Your Ref: OWPC14624
Our Ref: A/121/17/HH 21-06-2017
Please ask for:
Mrs A Gardner

Detached double garage & single storey extensions to existing garage.

Harcourt West Drive Angmering

<table><tr><td>PROJECT HARDCOURT West Drive, Angmering Littlehampton. BN16 4JE</td><td rowspan="4"> 29 Breach Avenue, Southbourne, Emsworth, Hampshire. PO10 8NB T: 01243 697164 M: 07879471666 www.pdkconsulting.co.uk</td><td rowspan="4"> PDK Architecture and Surveying</td></tr><tr><td colspan="2">DRAWING PROPOSED SITE PLAN</td></tr></table>

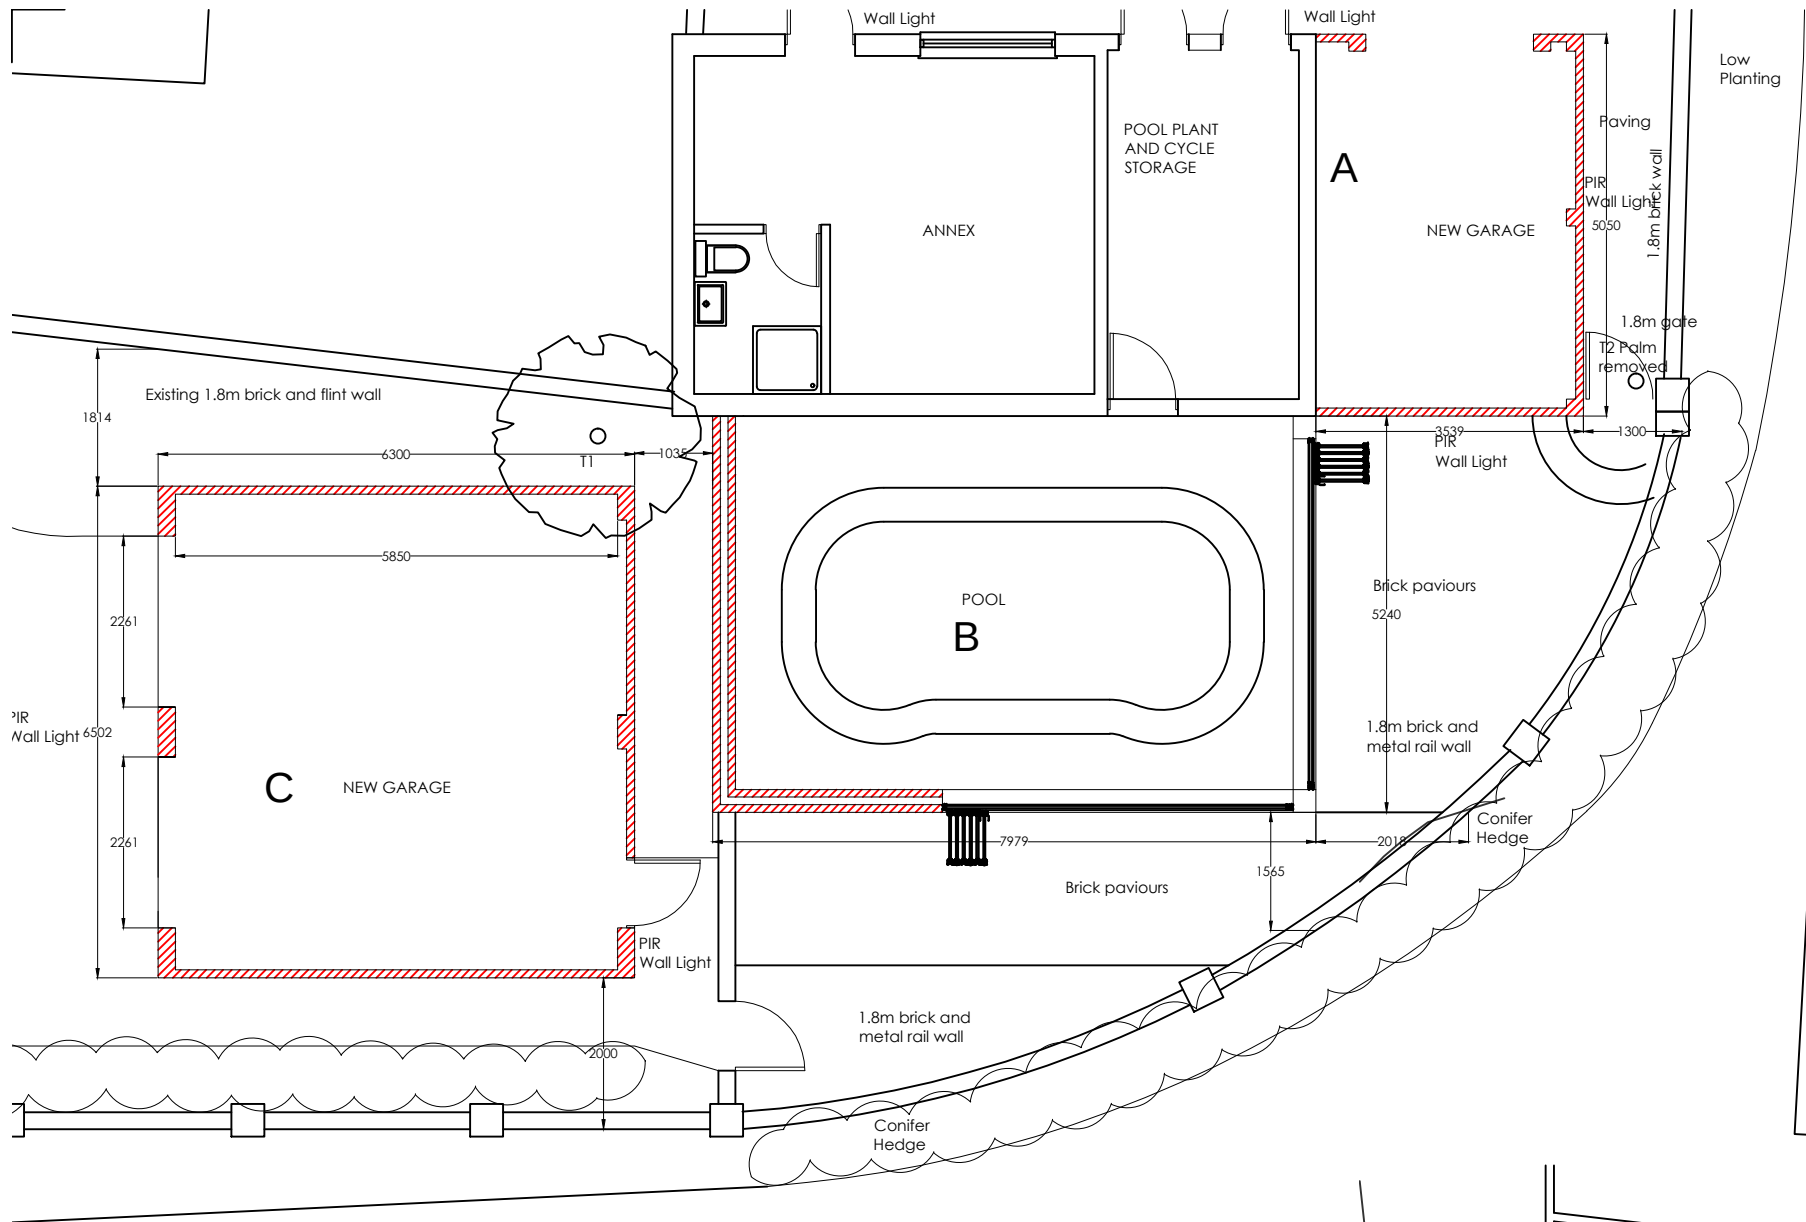
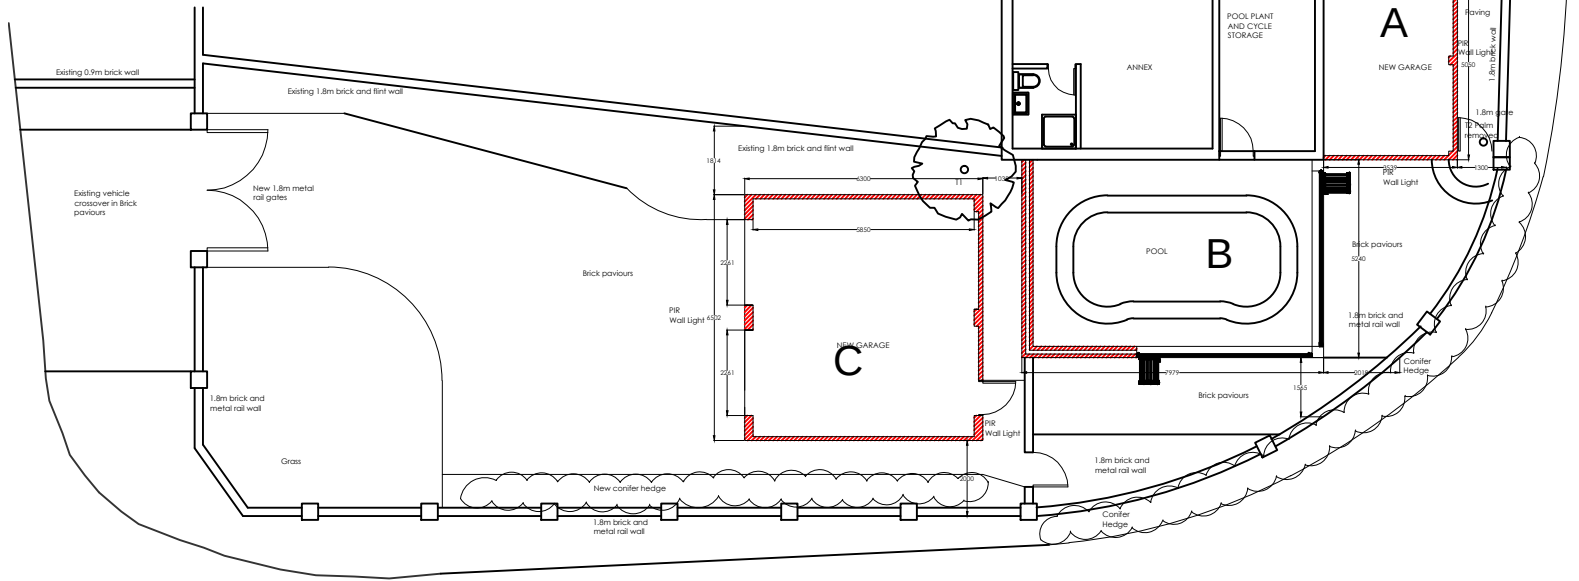
The proposed development will further reduce the site line to the adjoining road and will require an additional vehicle access to West Drive in a very dangerous and already restricted entrance to Ham Manor Golf Club.

The proposed buildings would look scrappy and untidy and are totally out of keeping with the area, a private residential, gated estate and are sited in front of the Building Line.

The site of the new garage is on land which was originally within the curtilage of the adjoining property Sunningdale but was retained by Mr Lehayne when he sold it to Mr Murphy.

The land has power cables running under it and also has covenants in favour of the Golf Club. The buildings and apron would create a drainage problem with run-off water which would flood the road.
